Application for Removal or Variation of a Condition following Grant of Planning Permission or Listed Building Consent

New one-and-a-half storey studio house to replace existing single storey house. Repair and renovation of existing single storey workshop.
Resubmission of 23/00211/FUL

23/02891/FUL

Condition 2 - Change list of approved plans with plans which take account of decision notice 23_02891_FUL-DECISION_NOTICE-6281711 and delegated officers report 23_02891_FUL-DELEGATED_REPORT-6281725:

drawing number AS 20
revision U

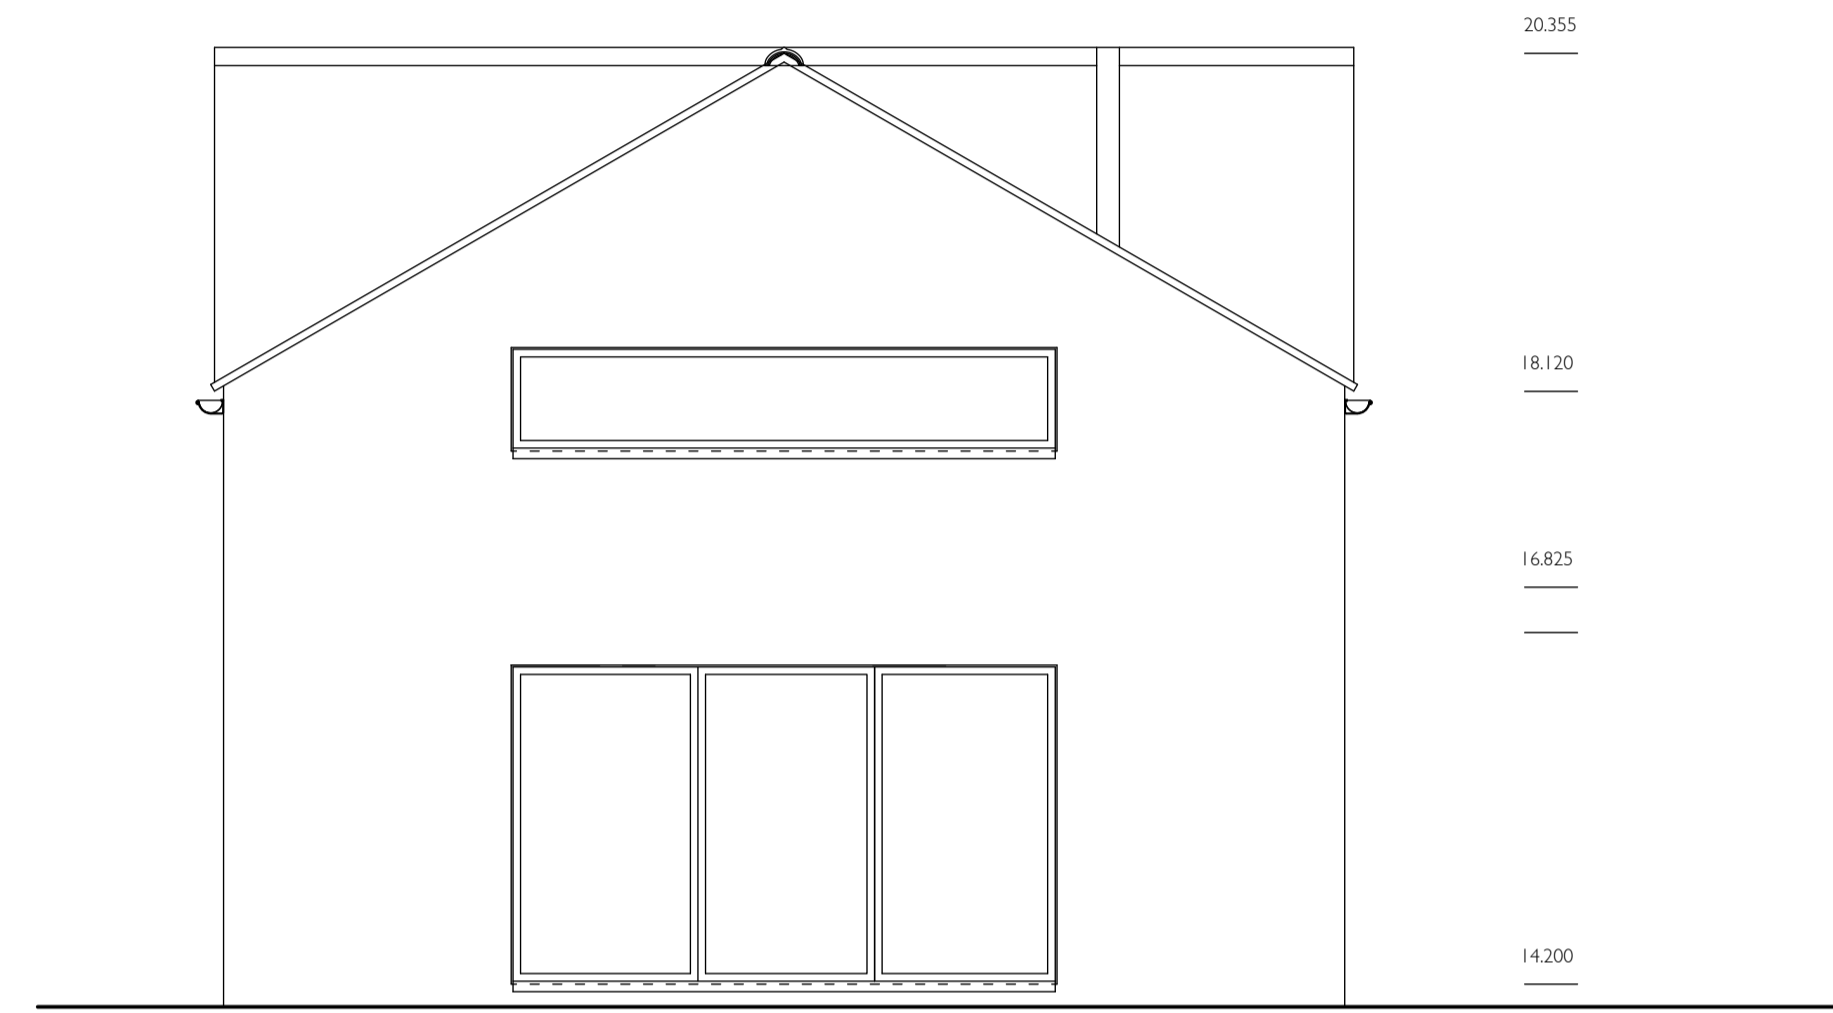
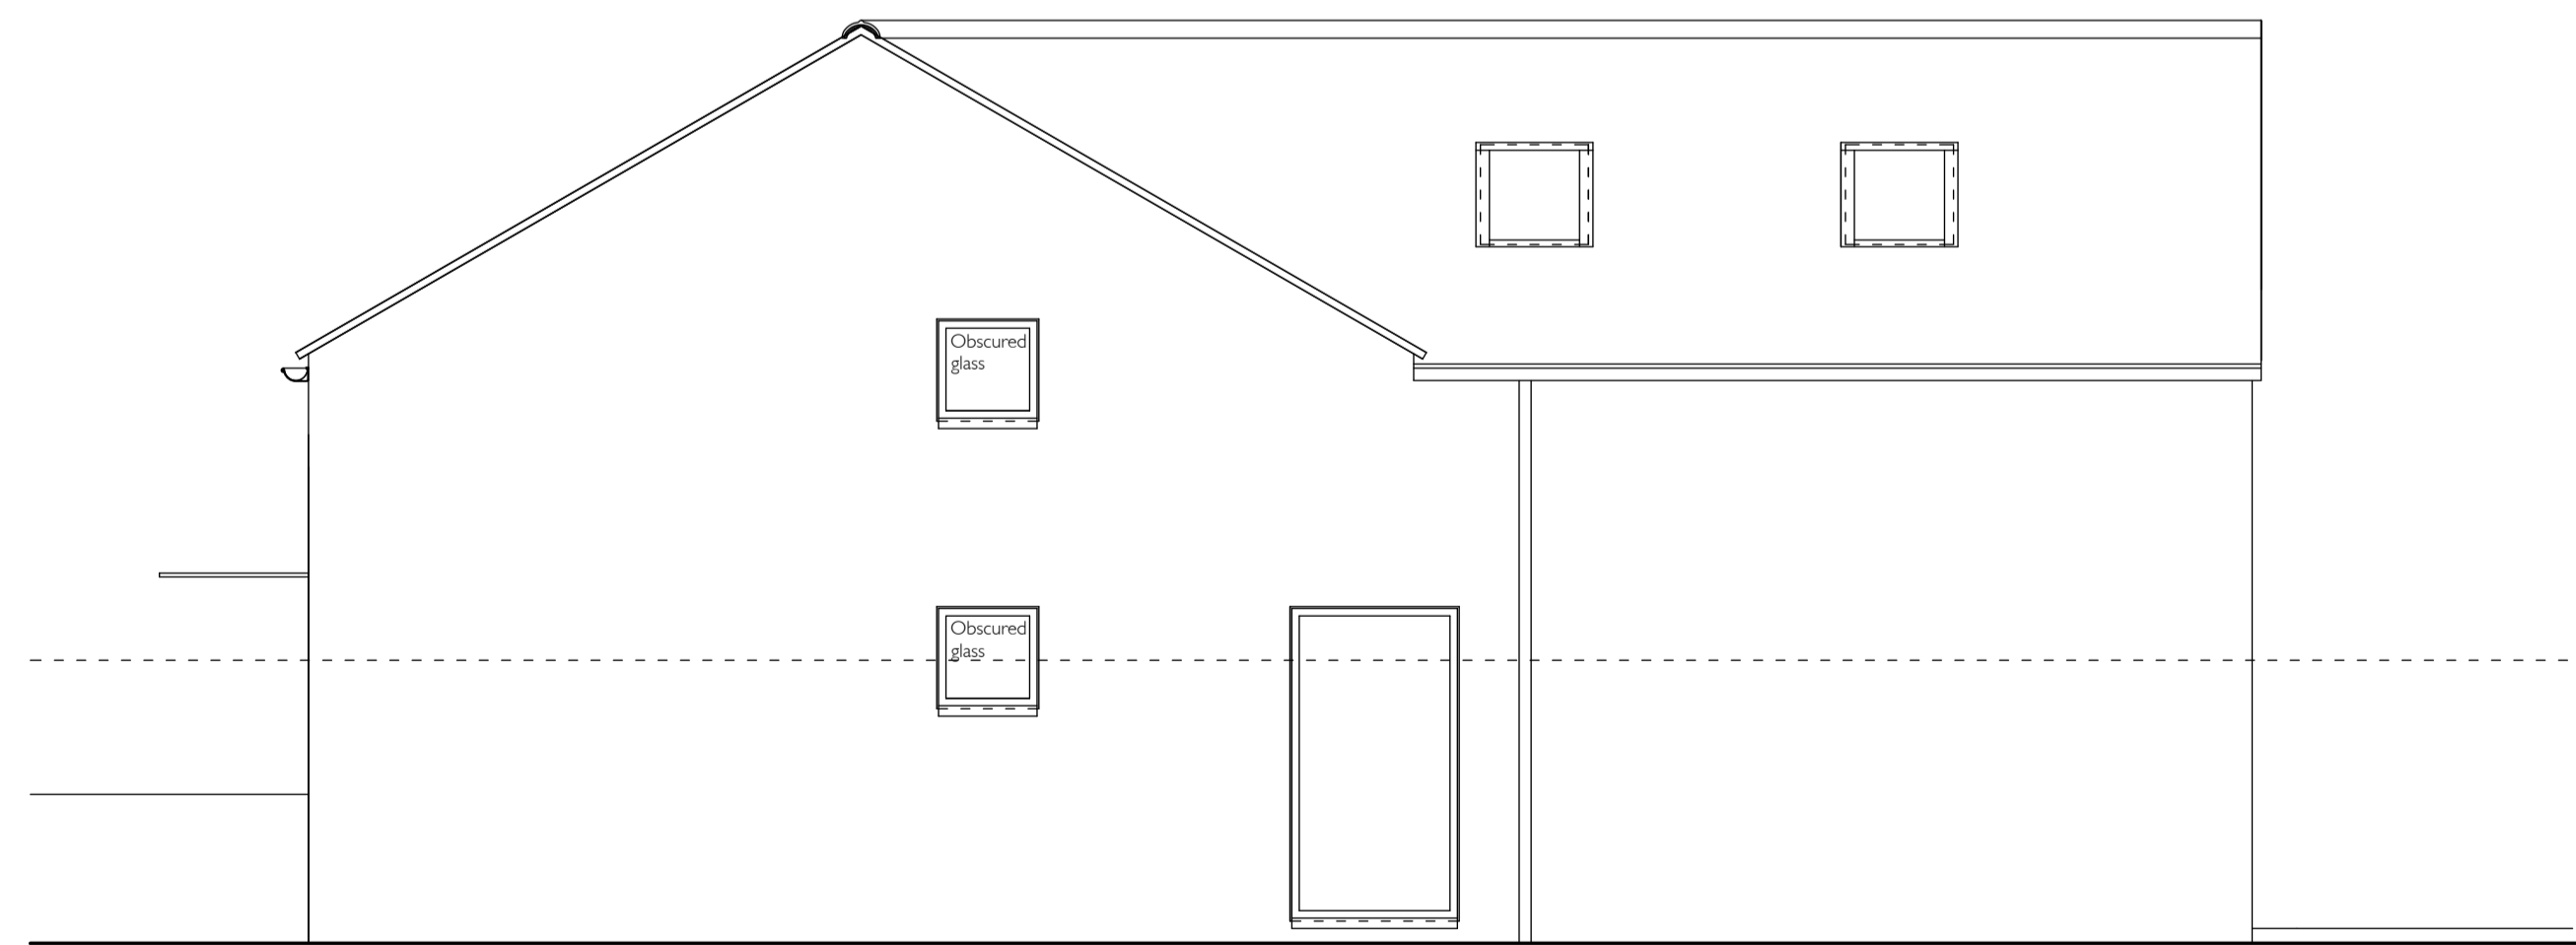
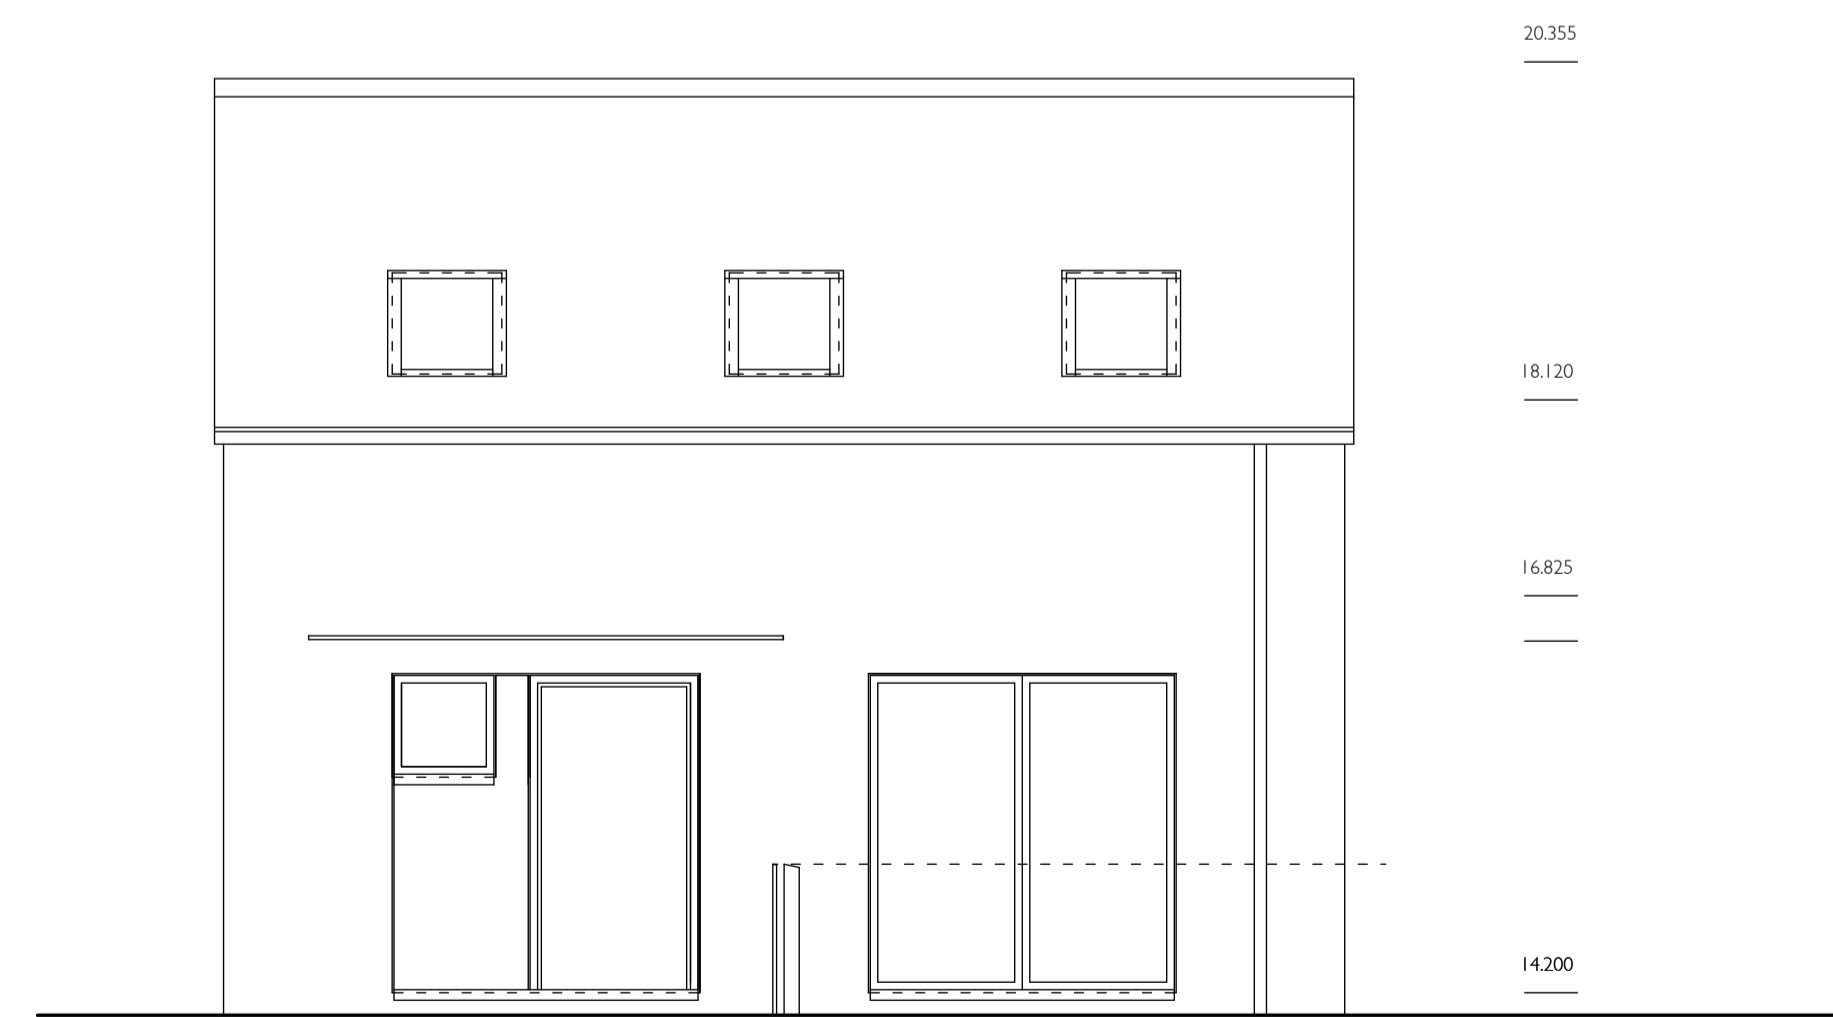
7.1 - Window removed from north elevation; entrance door moved to front (east) street elevation.

8.4 - Entrance door and window moved to front (east) street elevation, removing 'blank' appearance.

8.17 - Entrance door and window moved to front (east) street elevation, thereby avoiding 'problematic' placement.

In addition, the plans are varied to improve inclusive access with the repositioning of the stair and the layout of the shower/bathroom/WCS and kitchen, a window has been omitted on the south elevation, facing 25-27 Apthorpe Street.
